From: Amanda Scholes on behalf of Planning.Responses
Sent: 07 January 2019 11:32
To: Planning Scanning
Subject: FW: BN/50/18/PL The Fallows
Attachments: Surface Water Drainage Submissions Checklist 191218.pdf

Second drainage engineer comments

From: Laura Gibbons
Sent: 04 January 2019 13:55
To: Simon Davis
Subject: RE: BN/50/18/PL The Fallows

Drawing 23B – SW Drainage Plan
Scale 1:200 @ A3

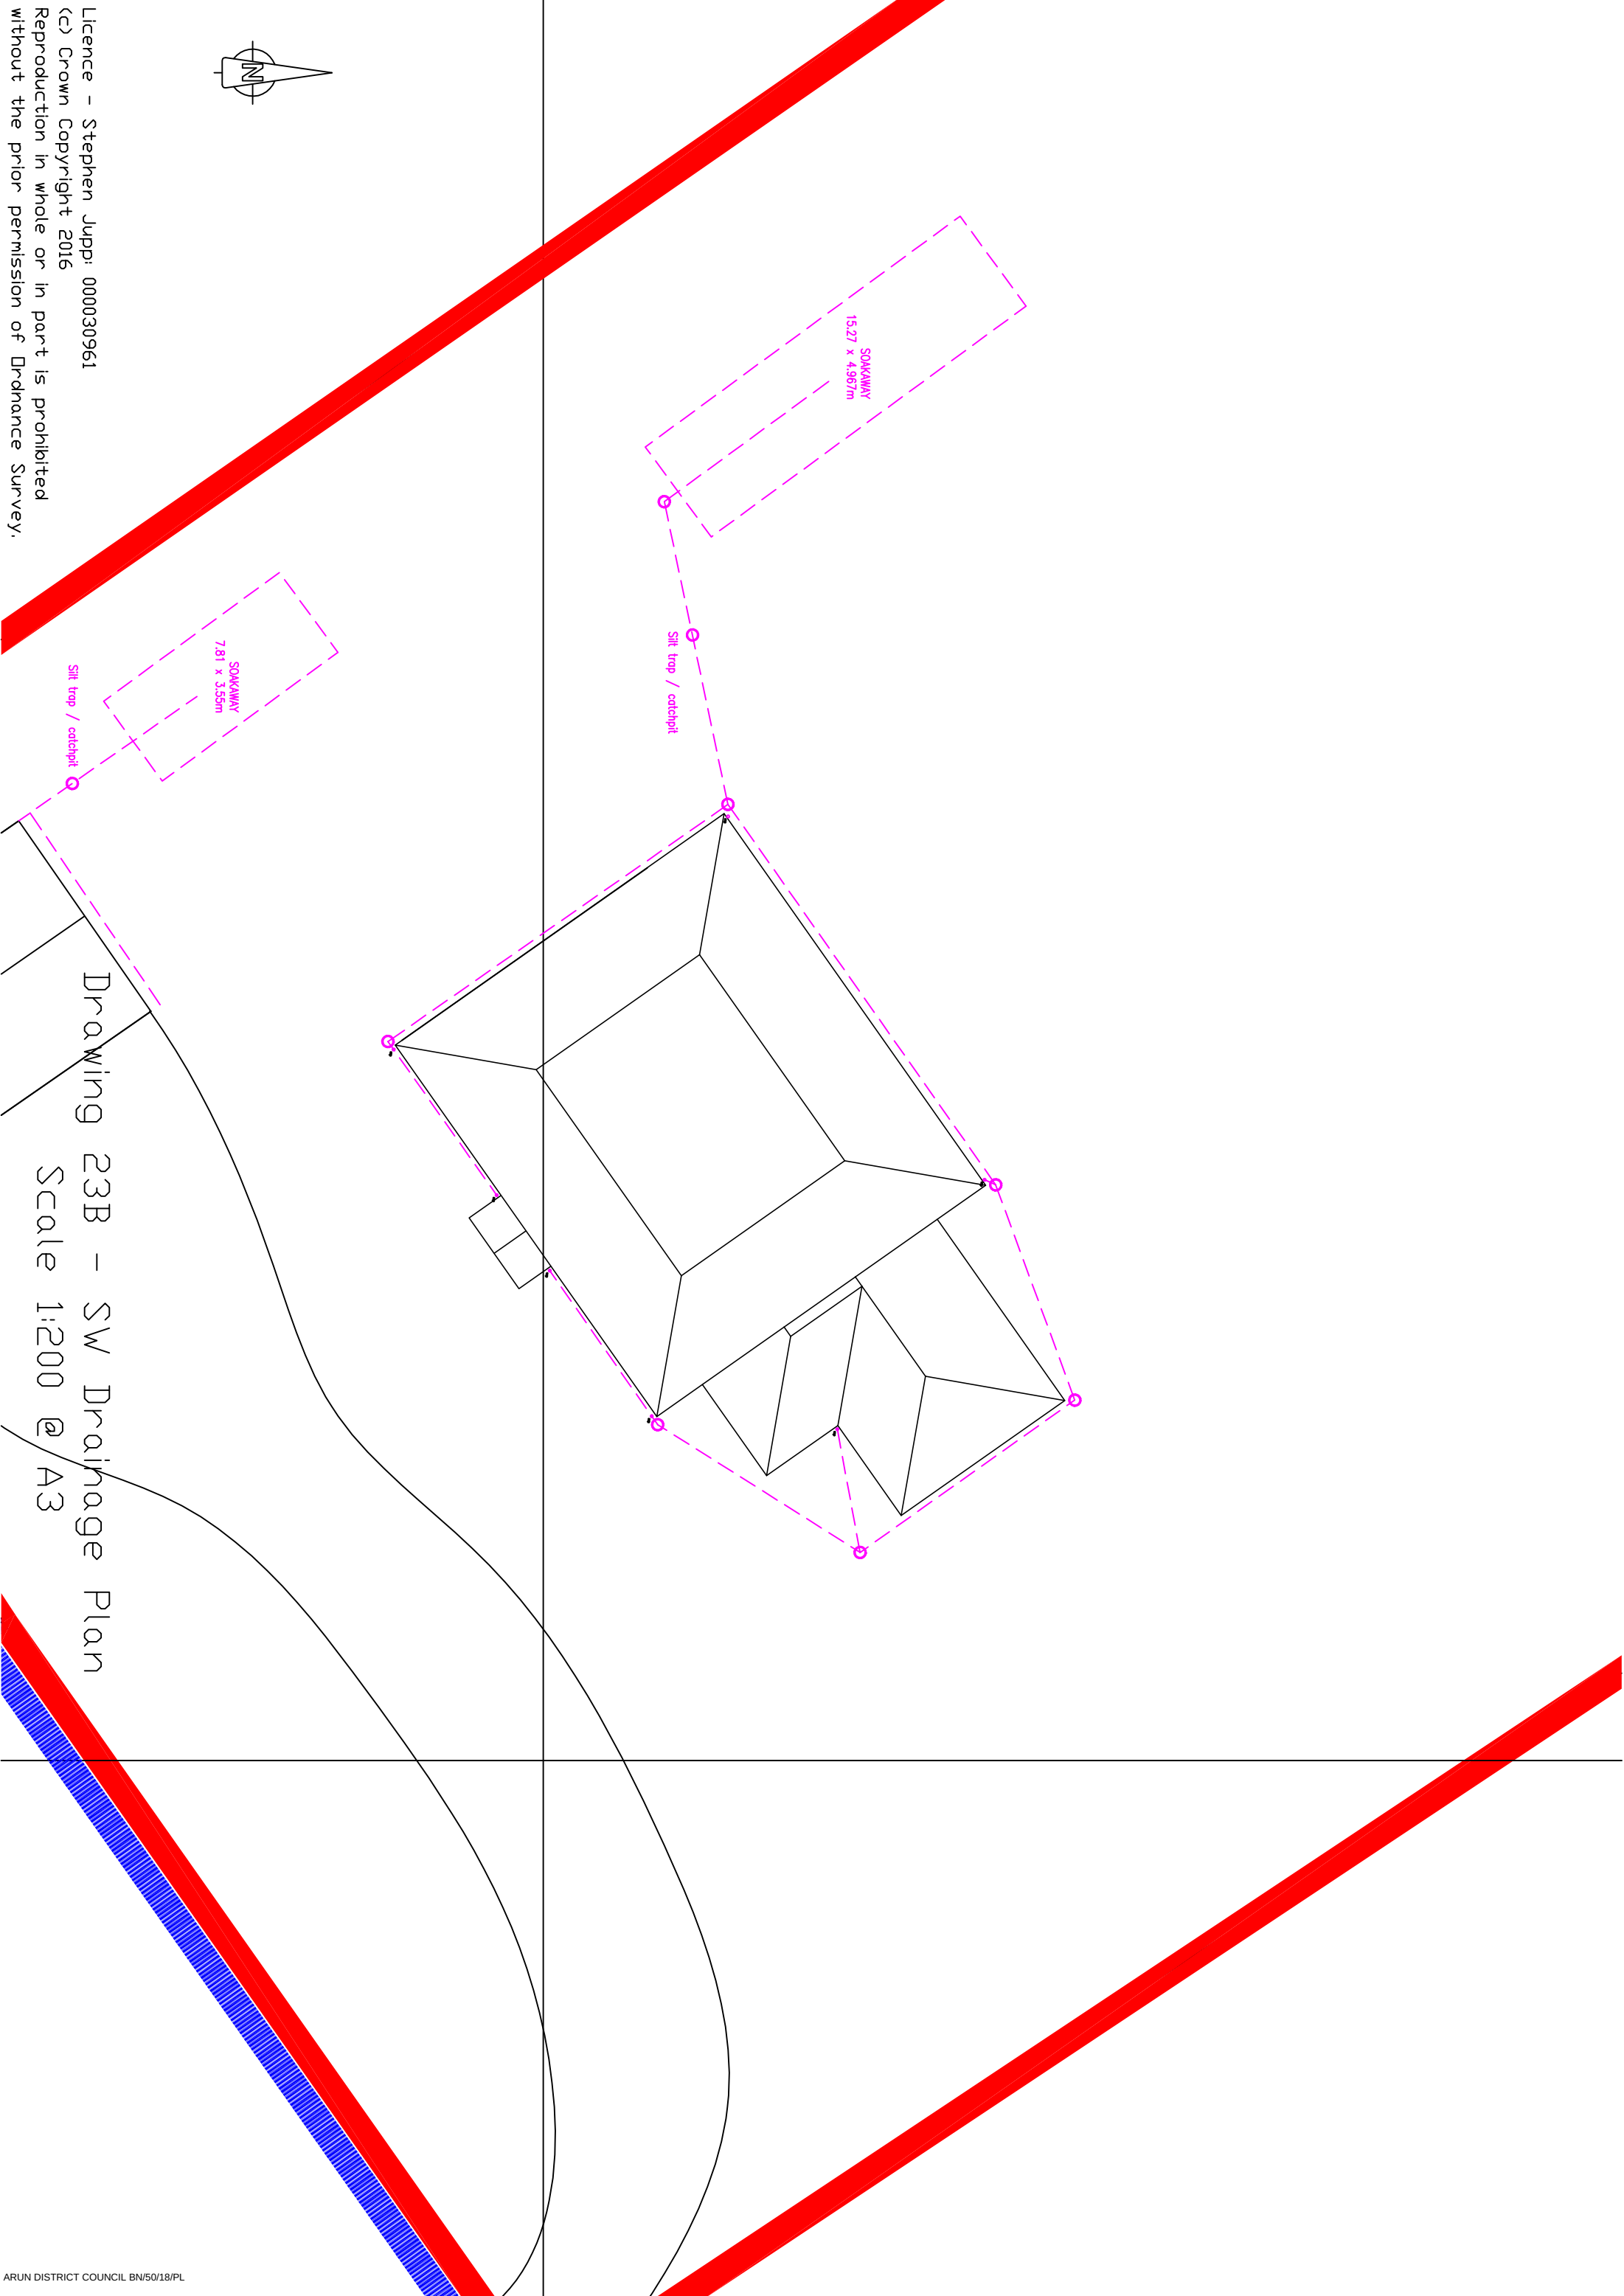
The condition is still required.

It is unclear from the supplied information if three consecutive infiltration tests were completed as is required. The information also states that a piezometer was installed to monitor ground water levels. These ongoing monitoring results have not been provided.

At DOC stage the applicant will need to ensure that our checklist (attached) is complied with. I.e. supply layout drawings and calculations too.
